Land at North West Bicester

Technical Note: Response to LLFA Drainage Comments: 24th May 2022

Date: June 2022

Appendix A – Illustrative Surface Water Drainage Plan (10663-DR-01 D)

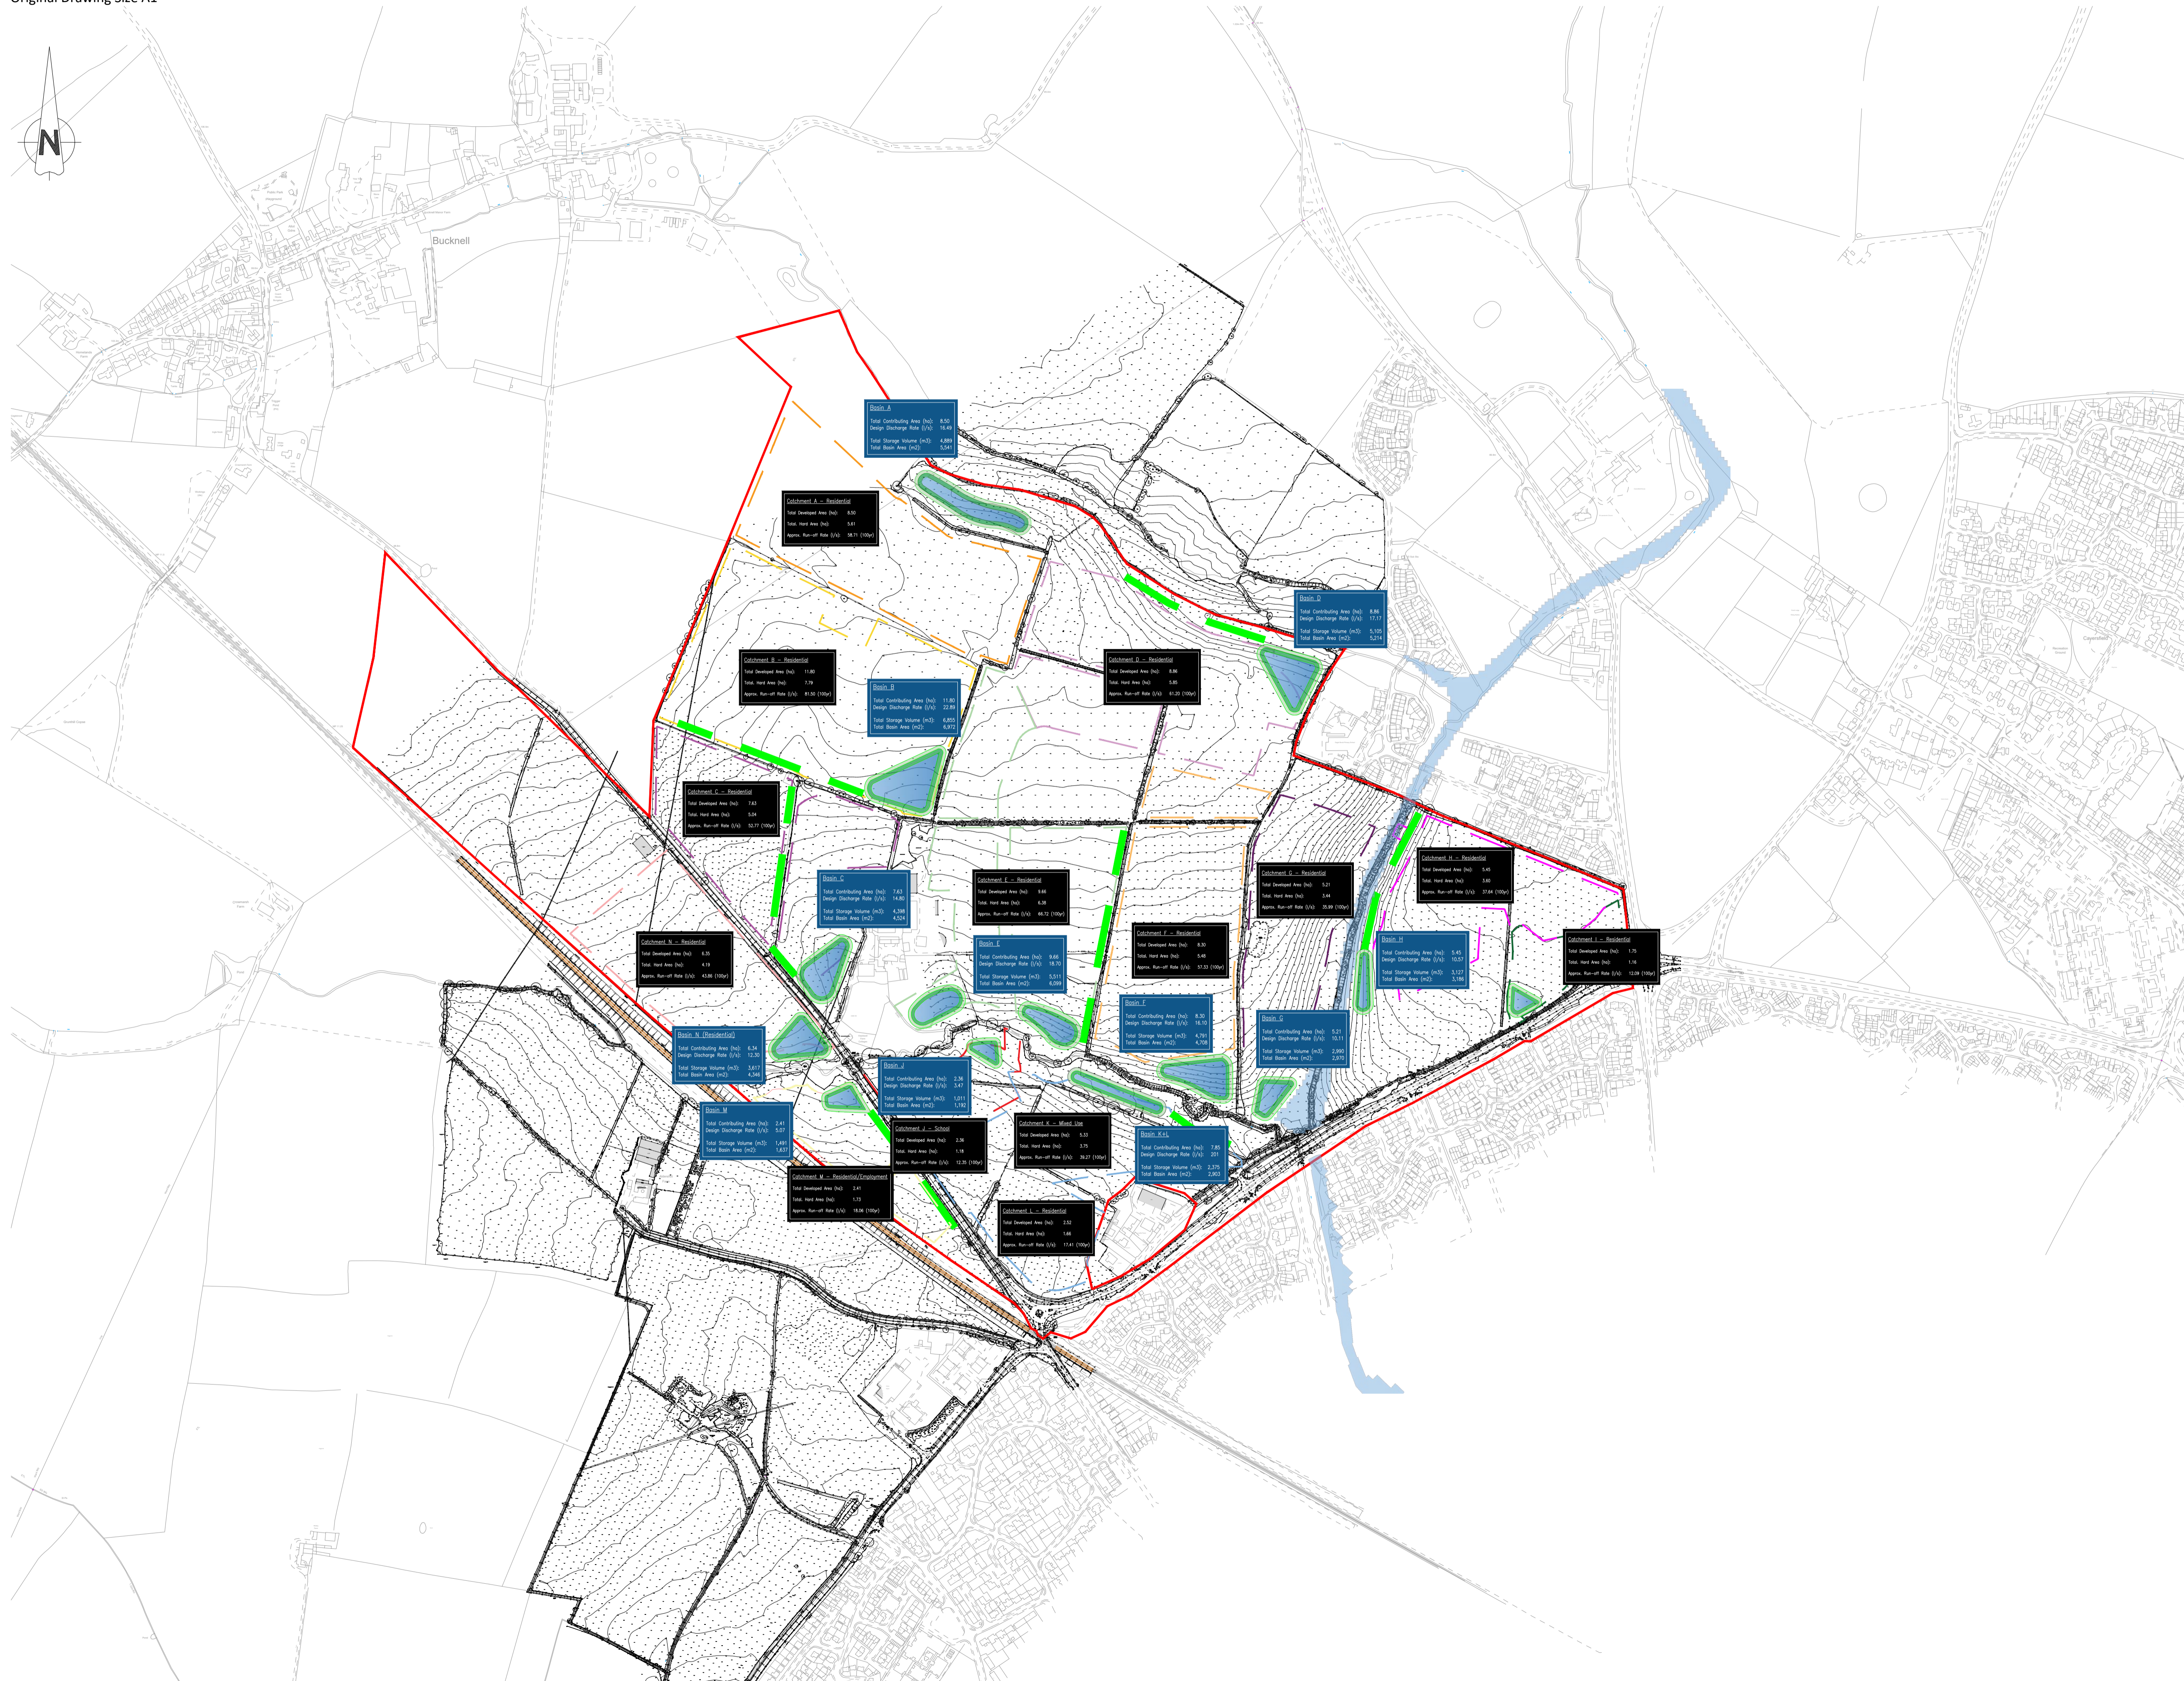
- 2.1 *Identify infiltration basins and attenuation basins clearly on the drainage drawing. Include arrows to indicate the outfall location to the watercourse with the discharge rate. For the infiltration basins provide the discharge rate used in m/s.*

- 2.7 *The ground investigation report shows the majority of the site to be suitable for infiltration, however the use of infiltration basins is not maximised. There are some attenuation basins that could be infiltration basins according to the infiltration testing report provided.*

- 2.2 The drainage plan has been updated to confirm whether each basin has been designed as attenuation or infiltration (this has been shown on the blue information boxes). For the attenuation basins, arrows have been provided to show which outfall the flow will be discharging to. Finally, the discharge rate for the infiltration basins have been altered from l/s to m/s. The updated plan is within [Appendix A](#).

- 2.8 Infiltration basins have only been utilised in areas where testing confirmed that infiltration is viable by having an appropriate half drain down time. More localised infiltration features such as permeable paving and

infiltration road side swales can be incorporated at the detailed design stage.
